**Alternative Use Boston Projects
Boston Alternative Energy Facility Order**

Planning Inspectorate Reference: EN010095

**Deadline 9 Representations by
the Environment Agency
Unique Reference Number: 20028344**

24 March 2022

**BOSTON ALTERNATIVE ENERGY FACILITY DEVELOPMENT CONSENT ORDER**  
 Regulation 5(2)(o) - Roman Bank within the Order Limits  
 BOSTON BOROUGH COUNCIL  
 Sheet 1 of 1

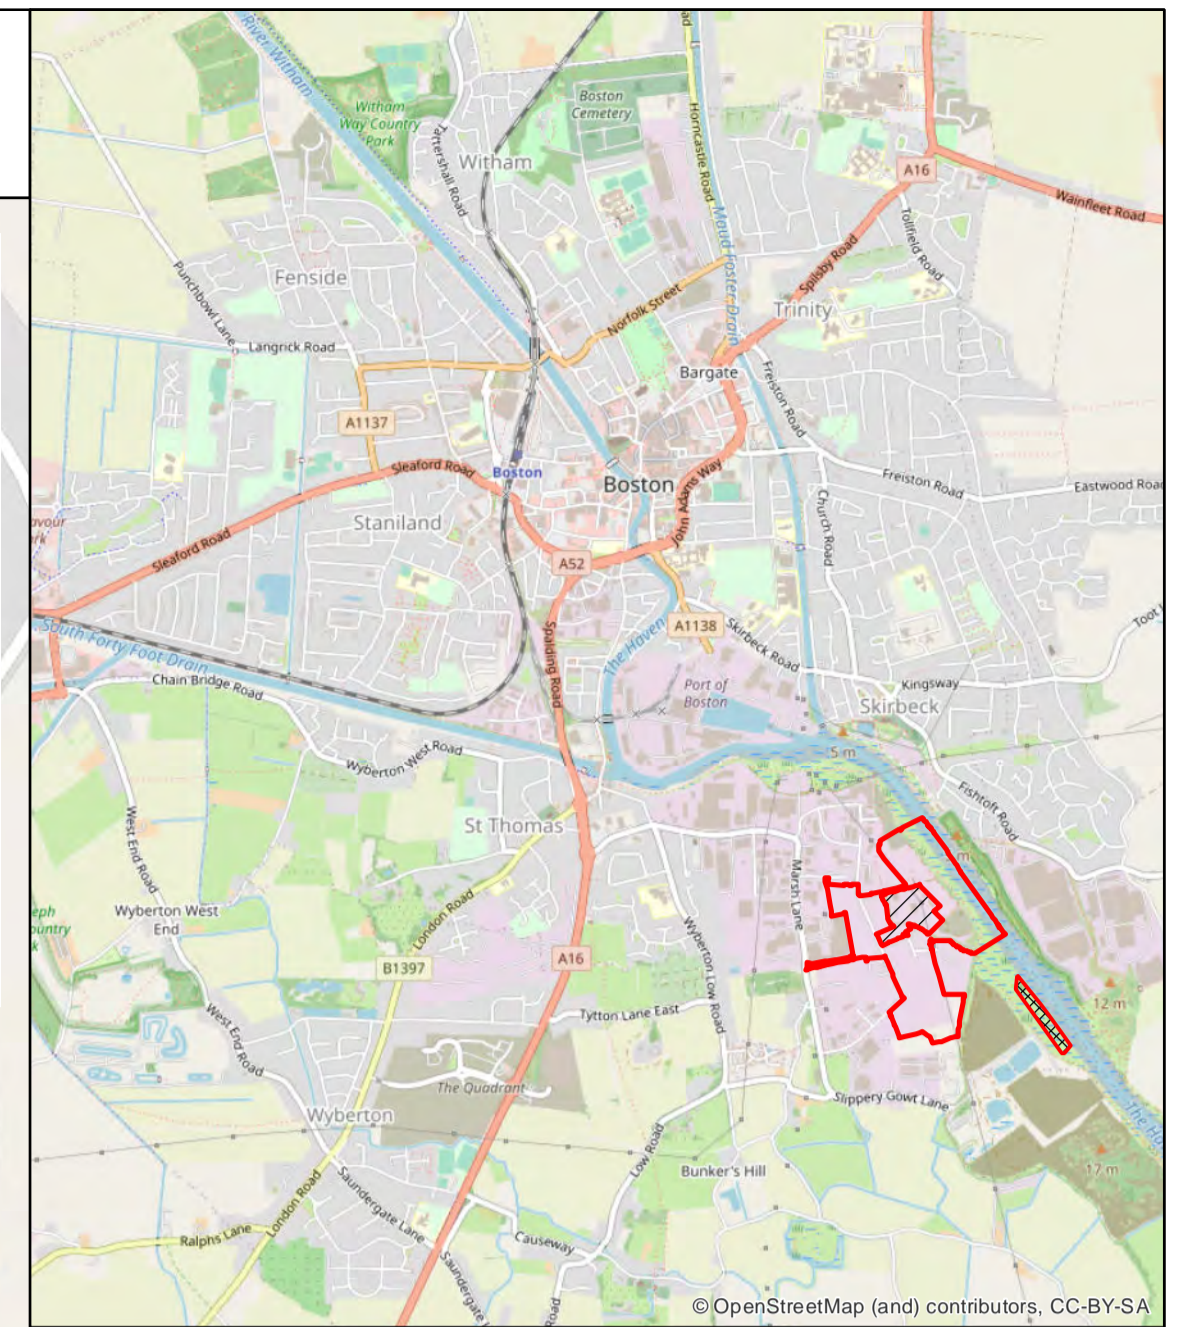
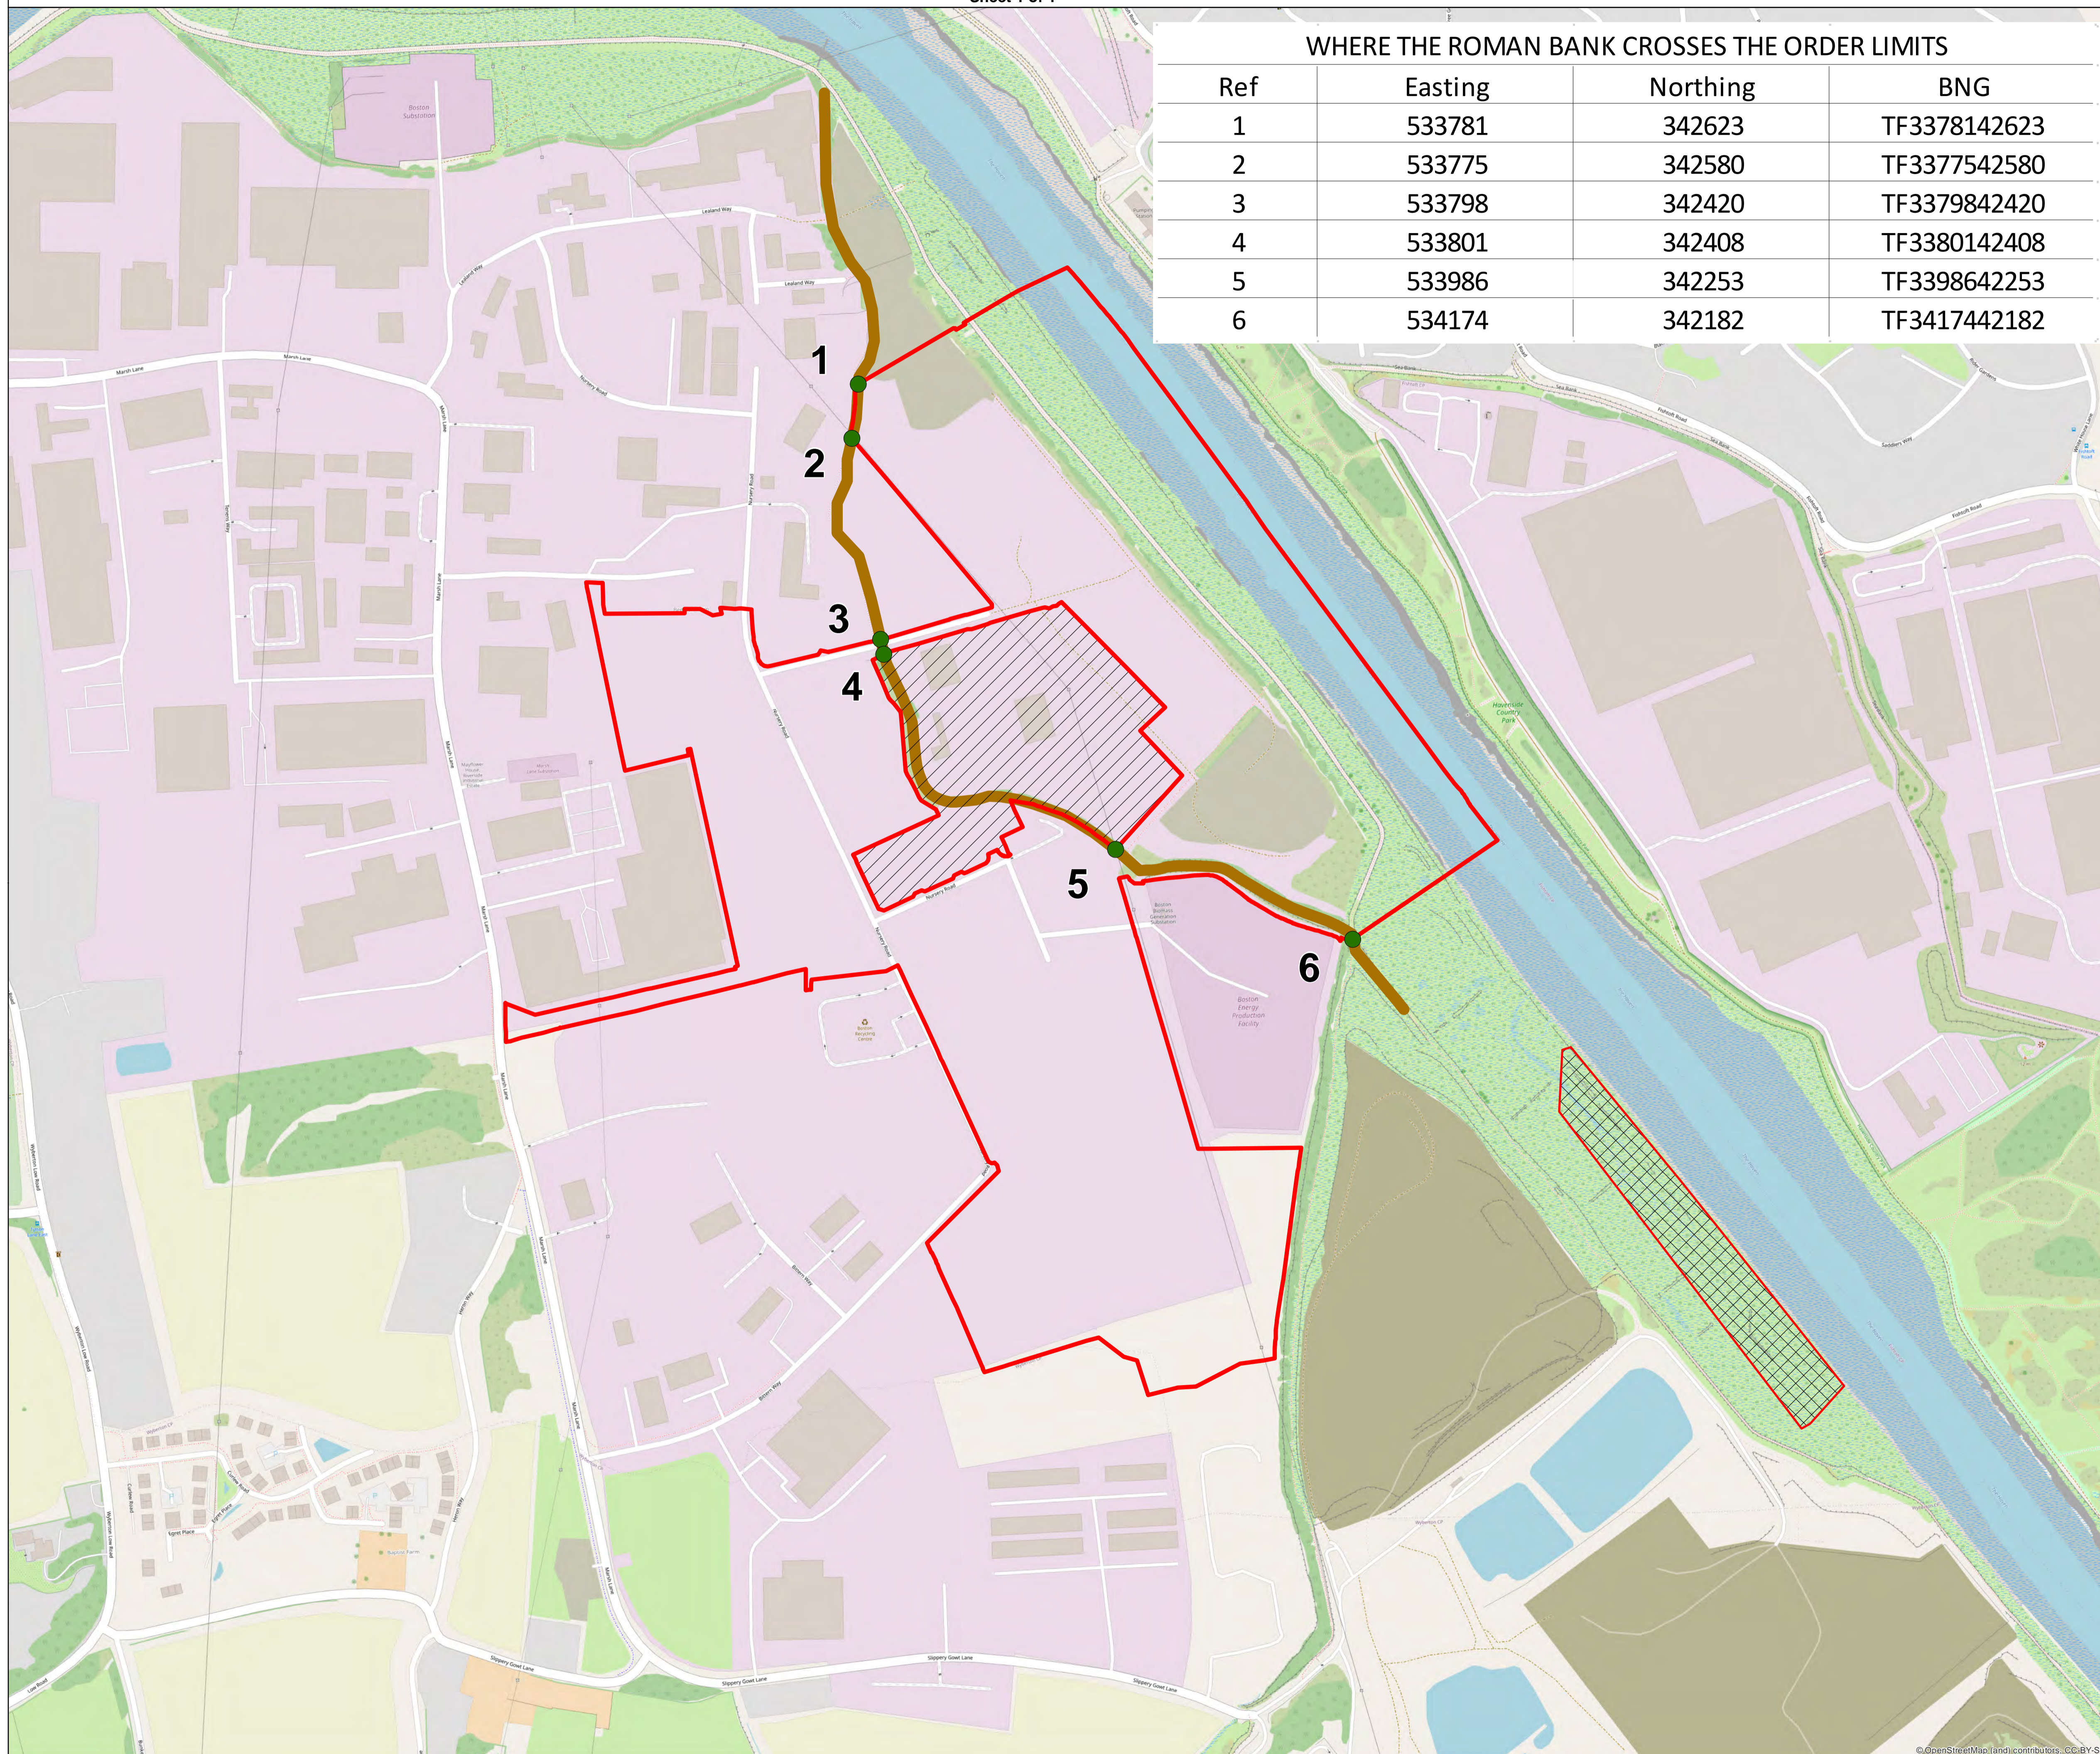
- 2.5. The applicant has also notified us of works that they may wish to undertake which will affect the Roman Bank sea defence. These include:
 - Clearing of vegetation to improve the accessibility of the public footpath along the line of the defence;

- Construction of a footbridge along the line of the flood defence;
 - Installation of a conveyor line crossing the flood defence;
 - Construction of an access road crossing the flood defence; and

- Construction of a drainage channel beneath the flood defence.
- 2.6. We have discussed these proposals with the applicant and it may be possible that the design of some these works will need amending to allow us to approve them at the detailed design stage in accordance with our Protective Provisions.

2.7. We do not consider that this needs addressing at this stage, but we wished to make the ExA aware that some aspects of the scheme may need to be altered to ensure that the functionality of the flood defence is in not in any way compromised by the proposed works.
